Appeal Decision

Appeal Ref: APP/T2350/W/22/3313514

9 Birtwistle Terrace, Langho, Blackburn BB6 8BT

- The appeal is made under section 78 of the Town and Country Planning Act 1990 against a refusal to grant planning permission.
- The appeal is made by Mr Neil Greenlees against the decision of Ribble Valley Borough Council.
- The application Ref 3/2022/0873, dated 5 October 2022, was refused by notice dated 1 December 2022.
- The development proposed is for the change of use and conversion of domestic dwelling into hairdressing salon.

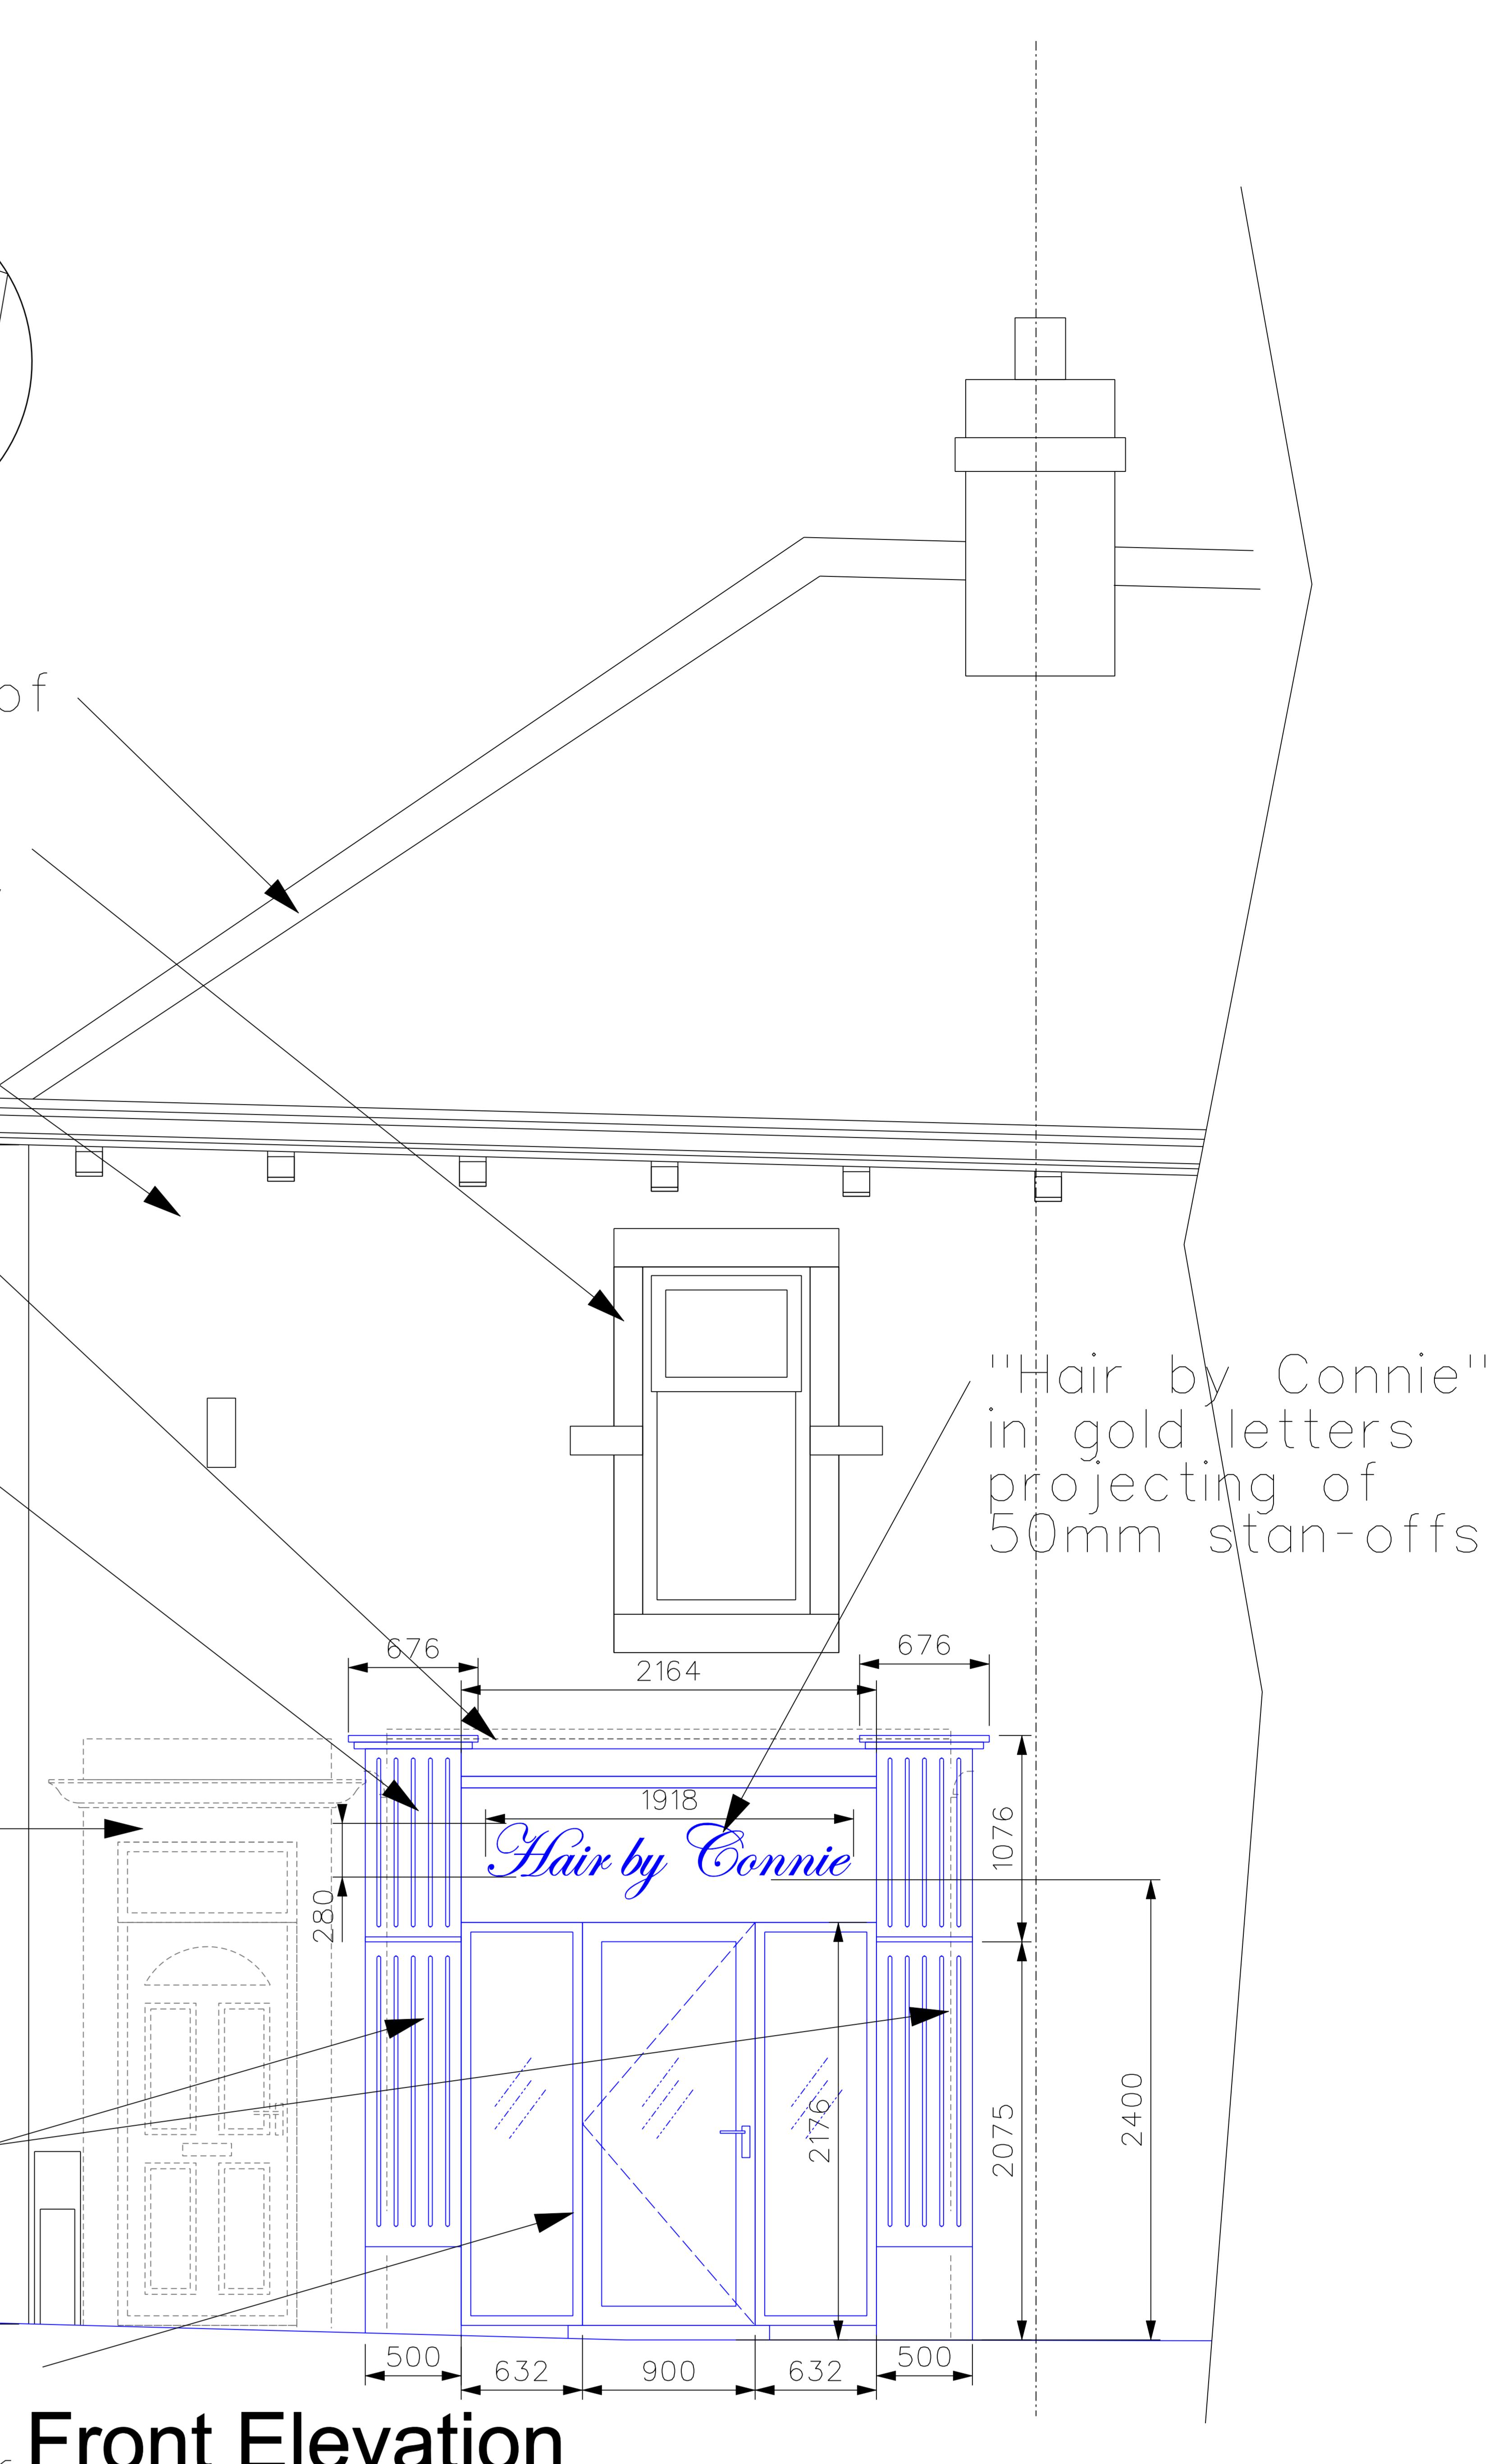
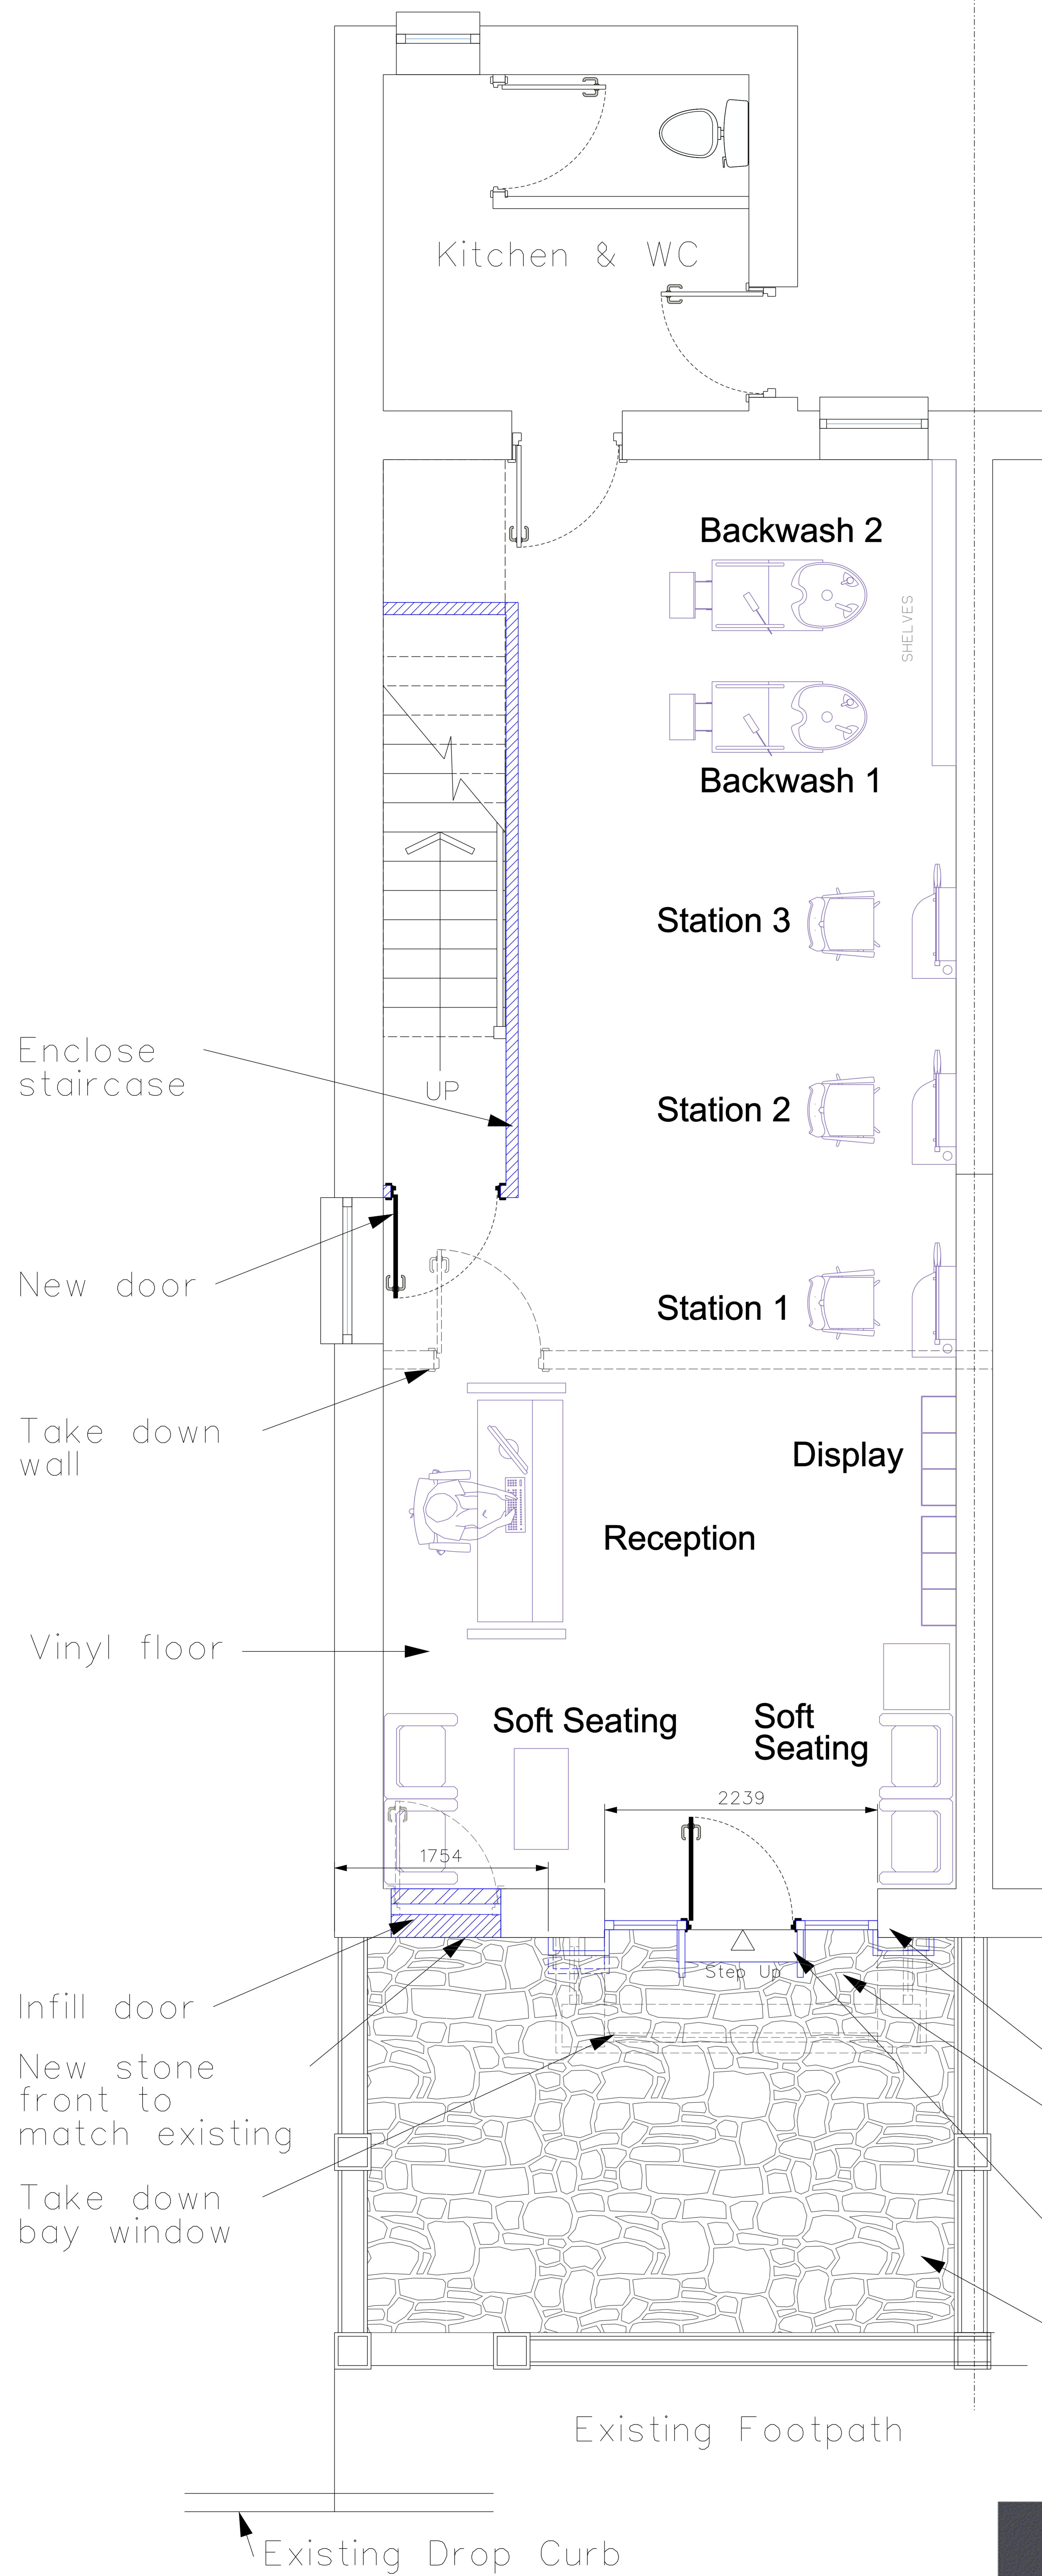
11. Despite this, both end properties on this terrace differ from others in that they each have ground floor bay windows. One end property on a neighbouring terrace also differs from others on that terrace as it has a commercial frontage at ground floor level. In this context, I do not consider the introduction of a traditional shop frontage of around the same height as the bay window it would replace, would be visually incongruous. The first-floor façade of the appeal property would also remain unchanged, other than the painting of an existing window. The removal of the existing front door would furthermore see its replacement with stone that matches the existing on the front elevation.

- 3) The external surfaces of the development hereby permitted shall be constructed in the materials shown on the submitted plan: Proposed Plan and Elevations (Drawing No: 22X048-002 Rev/Issue No: A).
